**Zipperer Short Plat - File Number SPF-21-00002 & SP-20-00005**  
**Condition Compliance Document**

**ZIPPERER SHORT PLAT, SP-20-00005
 SPF-21-00002**

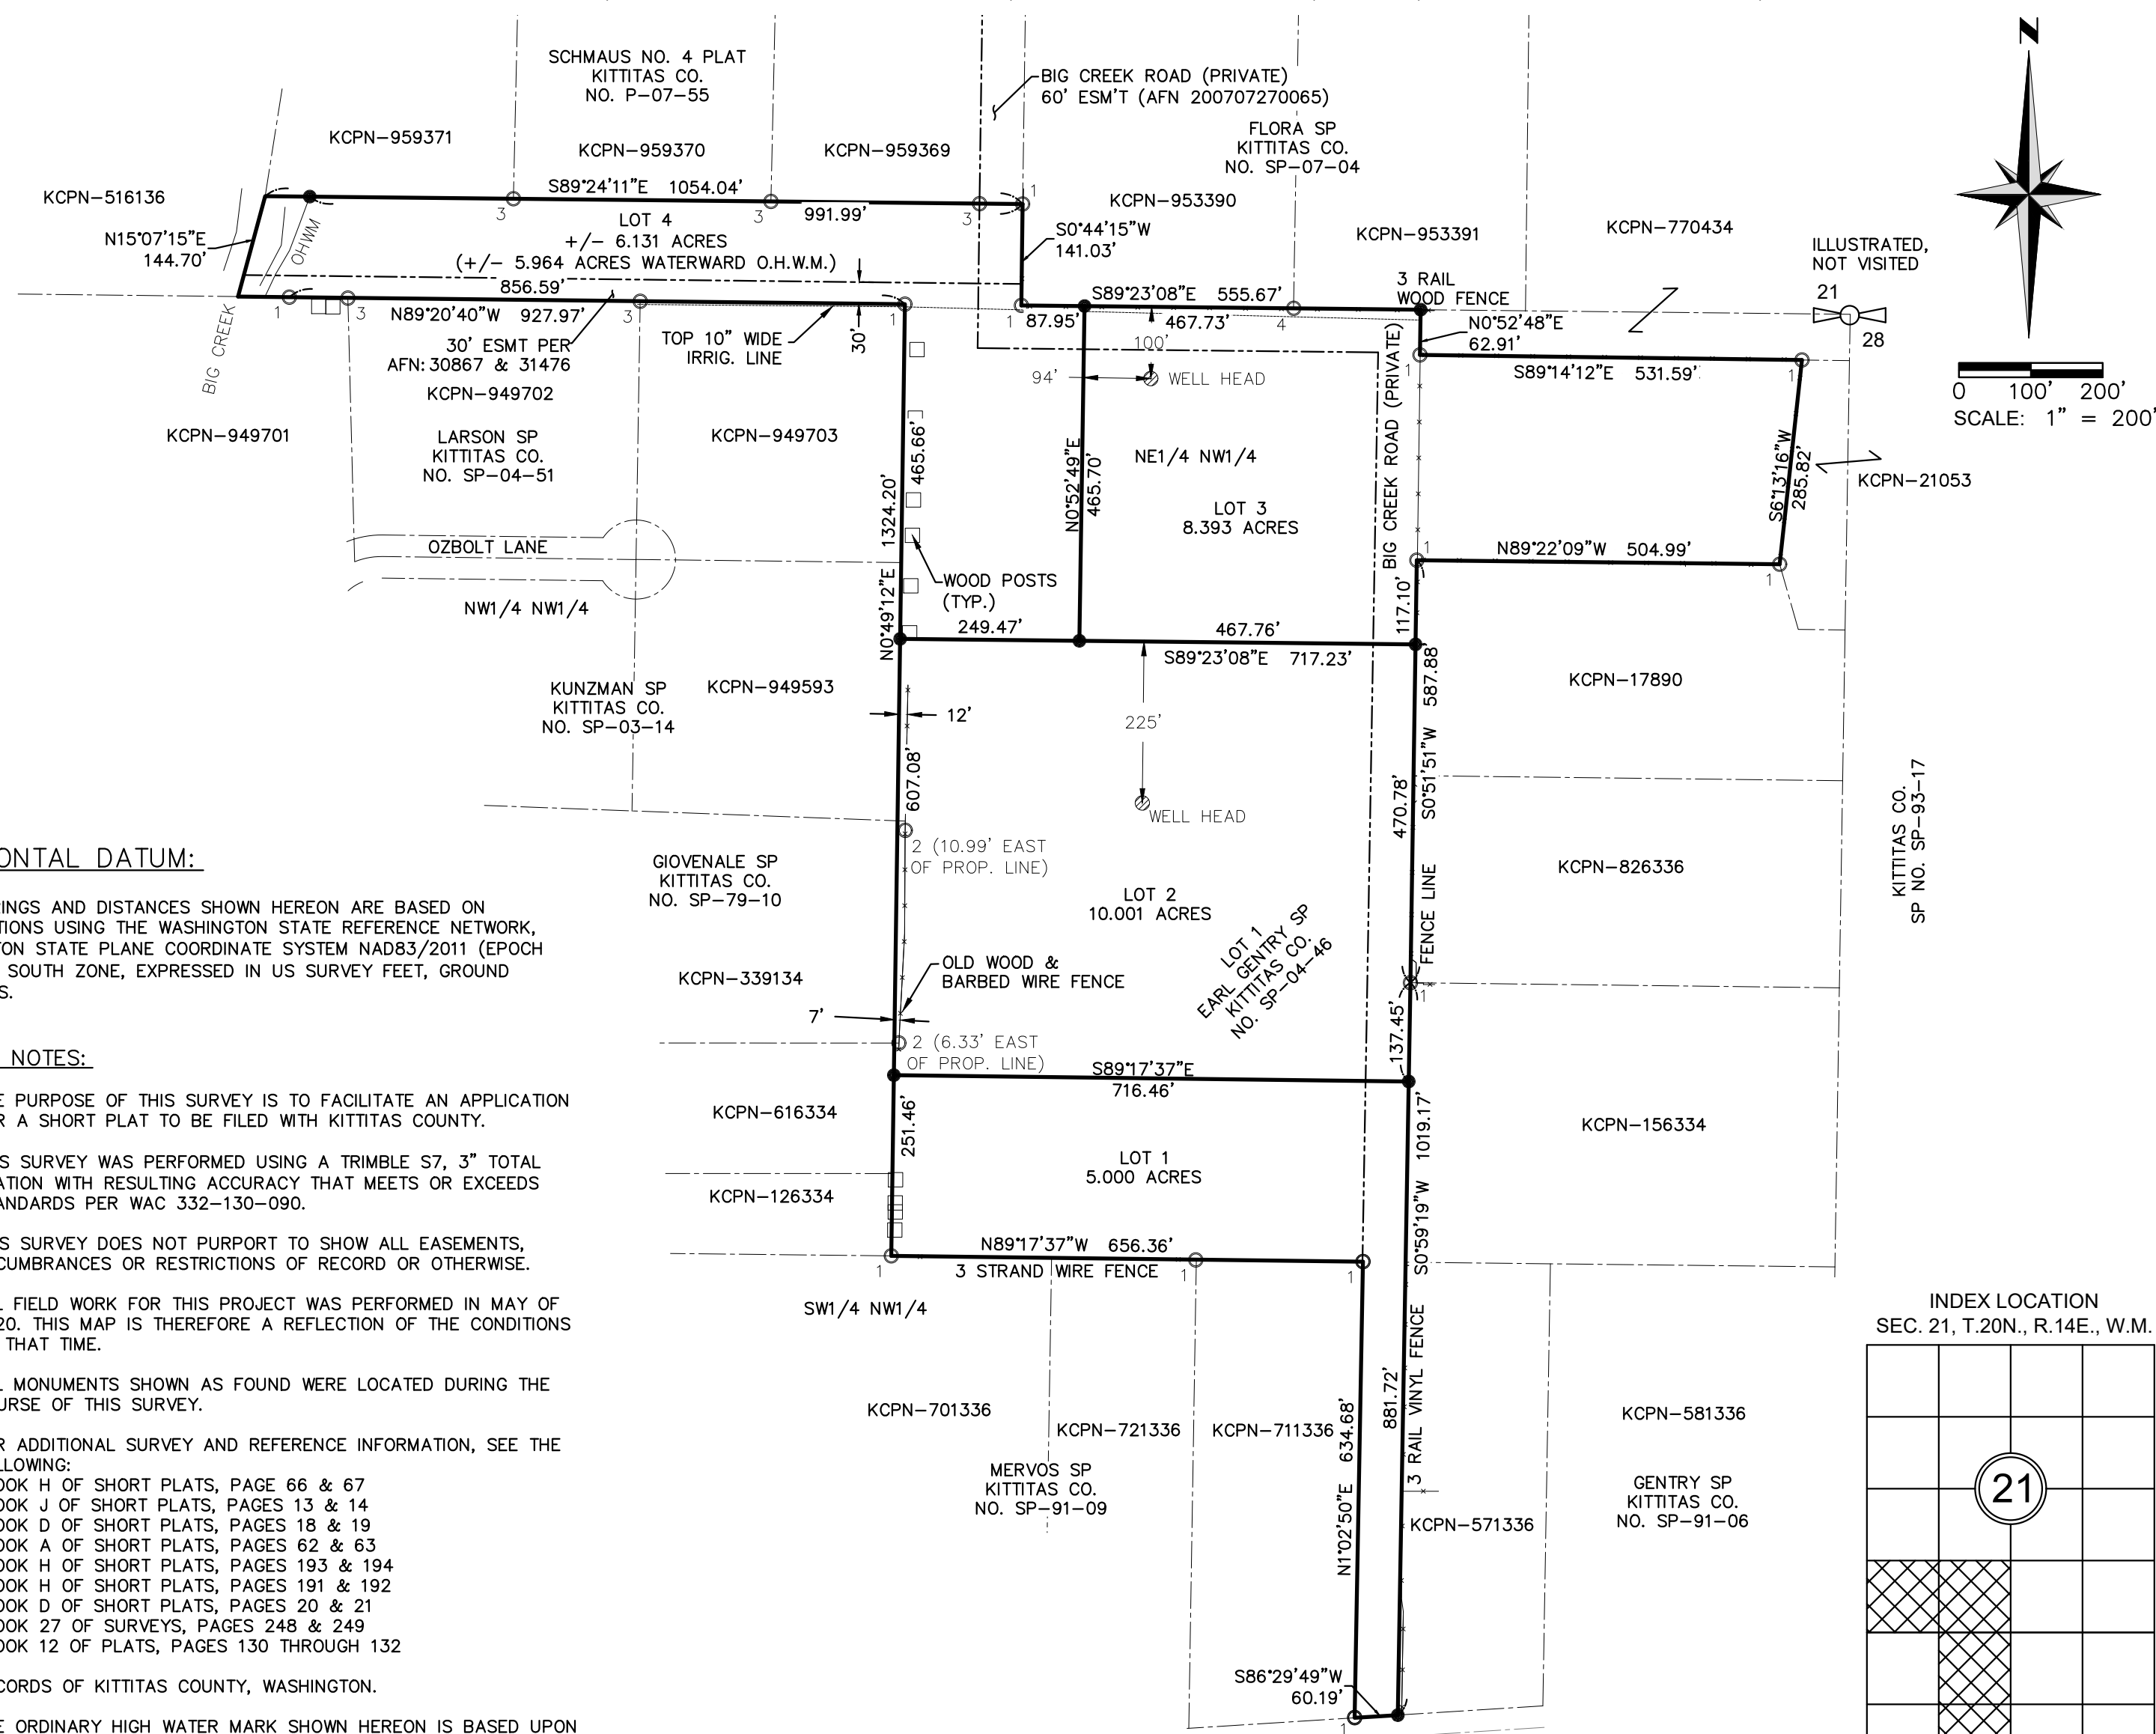
<u>Approval Condition</u>	<u>Applicant Response</u>	<u>Staff Review</u>
<b>KCCDS:</b>		
The final short plat number "SPF-21-00002" shall also be present on the face of the plat and located directly above or below the SP-20-00005 already shown.	Added as requested. Thank you for the SPF #.	
<b>Kittitas County Health Department:</b>		
Adequate water rights documentation needed.	Per email correspondence with Arden Thomas 6/2/2021, the Mitigation Purchase agreement included with the Final Short Plat Application satisfies the KCC 13.35.027b requirement. Per email from Jesse Cox to KCCDS 7/2/2021, this requirement has been met.	
Proof of adequate water supply requested.	Well logs for existing wells were also submitted with the Final Short Plat Application dated 3/22/2021. Per email from Jesse Cox to KCCDS 7/2/2021, this requirement has been met.	
Wells must meet the 50' setback requirement and site plan must show proposed drilled wells.	A revised lot layout is included to meet this requirement. Lot closures for the requested revised lot layout are also included.
